Please find amended plans showing a reduced car barn as discussed during our telephone conversation this morning.

Amended drawings from my point of view (waiting for Martyn's comments)
However, the proposed Car Barn has rather prominent position and it is too dominant and even larger (southern elevation) than the barn 3 itself. It should be amended; simple structure to serve the use.

Please find amended plans addressing the concerns raised in our numerous correspondence. The key amendments are as follows:

Drawing Title
Proposed Plans - Barn 1

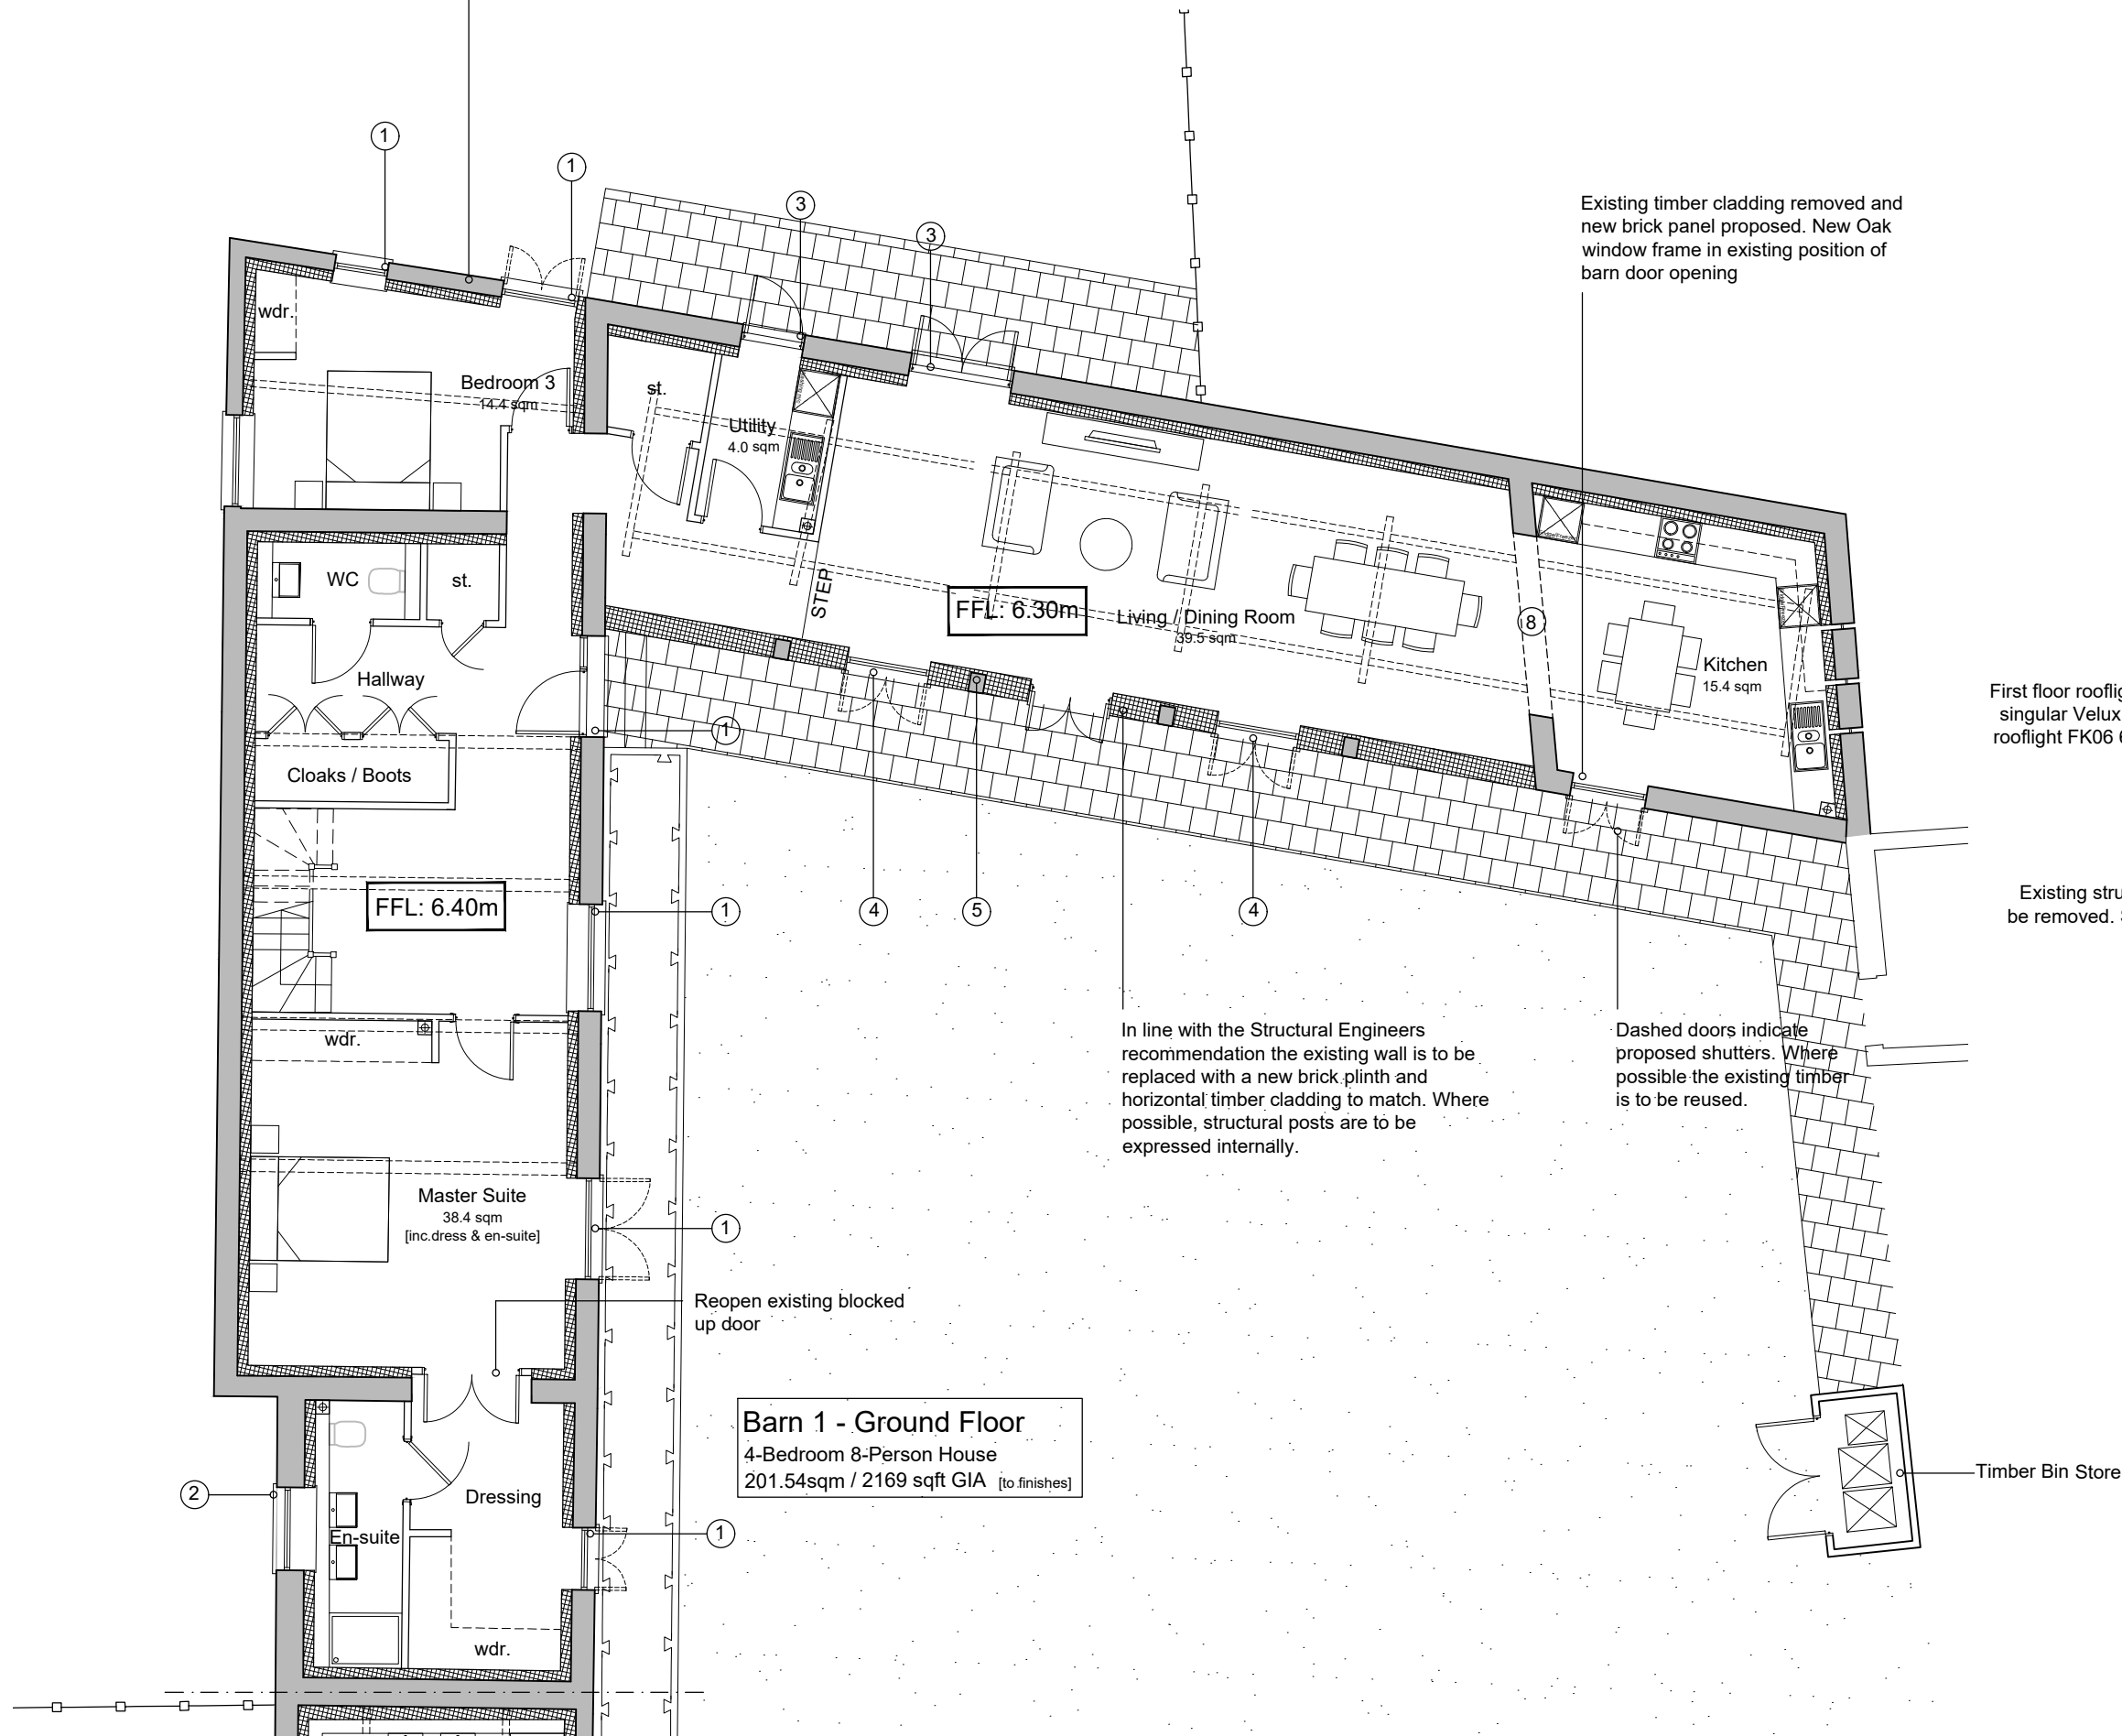
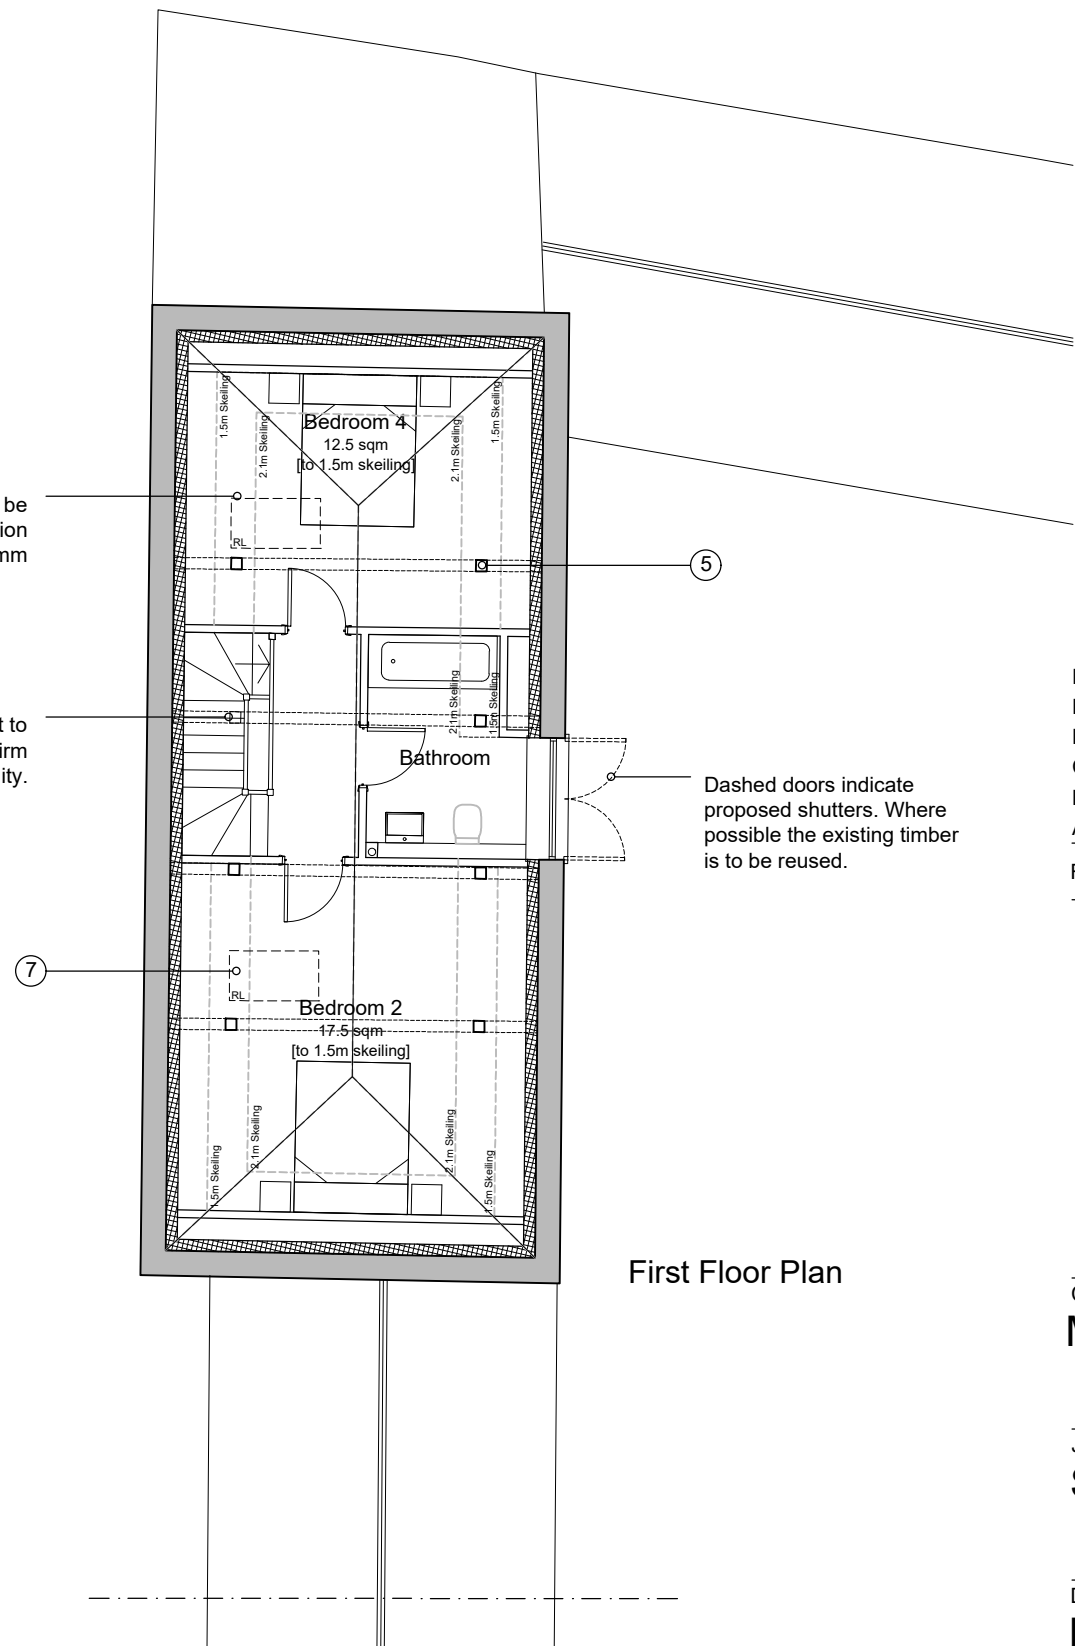
- Amount of conservation rooflights reduced to just two (one per bedroom) located on less prominent north western elevation.
- South elevation amended so size and position of new windows and doors reflect existing.
